Objection Letter (Updated with CDC, Survey Evidence, EIS Inconsistencies, Structural Risk & Sunlight/Shadow Issues)

To: NSW Department of Planning, Housing and Infrastructure Re: SSD-83478456 - Residential Development (21-25 McIntosh St & 55 Werona Ave, Gordon) From: Owner - 12 Forsyth Street, Killara NSW

- Units types
- 1 Bed
 - 2 Bed
 - 3 Bed
 - Balcony
 - Bicycle
 - Lobby

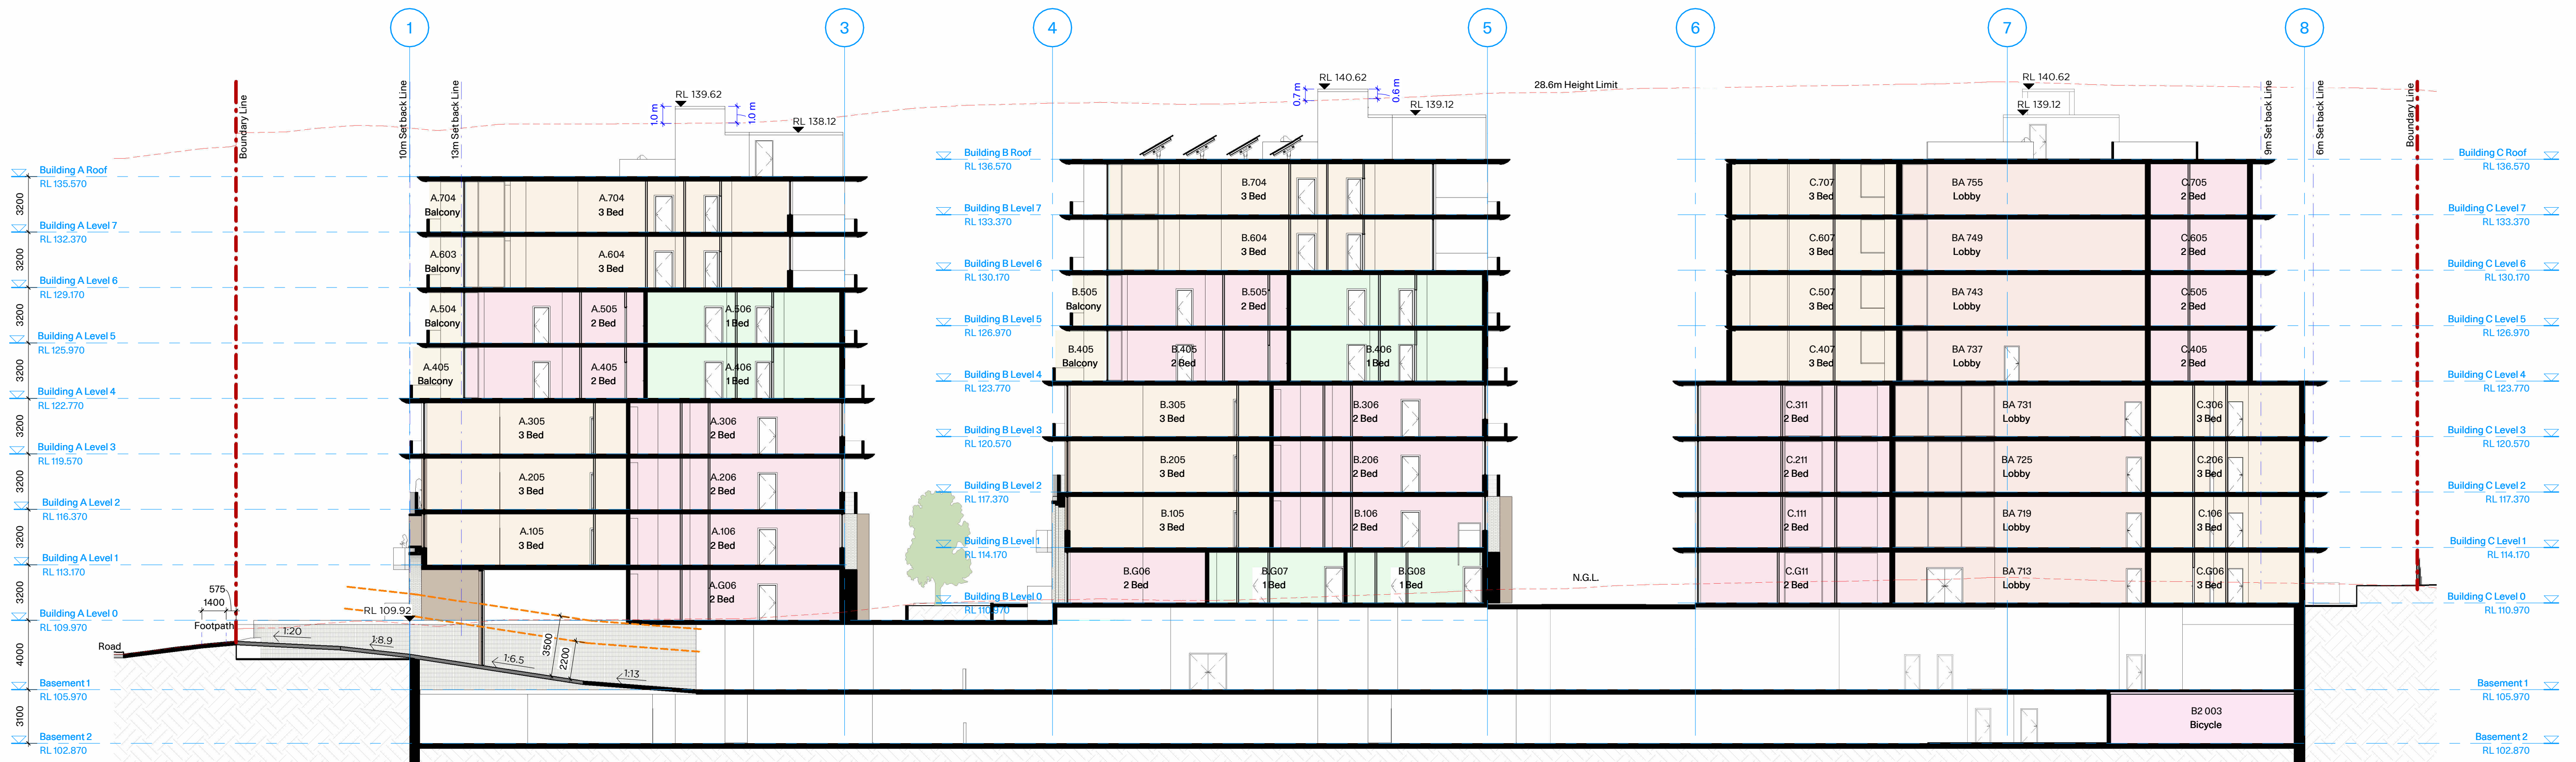
- **Fact:** The proposal seeks heights of up to 30.5 m (Appendix B - Statutory Compliance Table, page 12), above the TOD limit of 28.6 m.
- **Clause 4.6 Request:** The applicant relies on Clause 4.6 of the Ku-ring-gai Local Environmental Plan 2015 to justify this breach. Clause 4.6 allows flexibility only where strict compliance is unreasonable or unnecessary, and where better planning outcomes are achieved. In this case:
 - The objectives of the height control (protecting neighbourhood character, preventing overshadowing, preserving amenity) are not met.
 - The exceedances (up to 6.6% or 1.9 m for lift overruns and roof spaces) provide no genuine public benefit and instead cause

- adverse amenity impacts.
 - The request is therefore both unreasonable and unnecessary.
 - **Comparison:** My CDC-approved house ridge height is only 8.5 m (CDC Stamped Plans, Elevations, pages 5-6).
 - **Impact:** Their proposal is nearly three times taller, overwhelming the low-density streetscape and undermining the intent of planning controls.
-

1. Reduce overall height to ≤ 5 storeys (≤ 17 m to top of parapet) across all buildings.
2. If not feasible, step down the block closest to Forsyth Street by $\geq 2-3$ storeys, and increase the southern setback so that overshadowing to 12 Forsyth St is mitigated to ≥ 3 h midwinter.
3. Remove/shorten lift overruns, rooftop plant rooms, and balustrades so that no element exceeds the 28.6 m control.
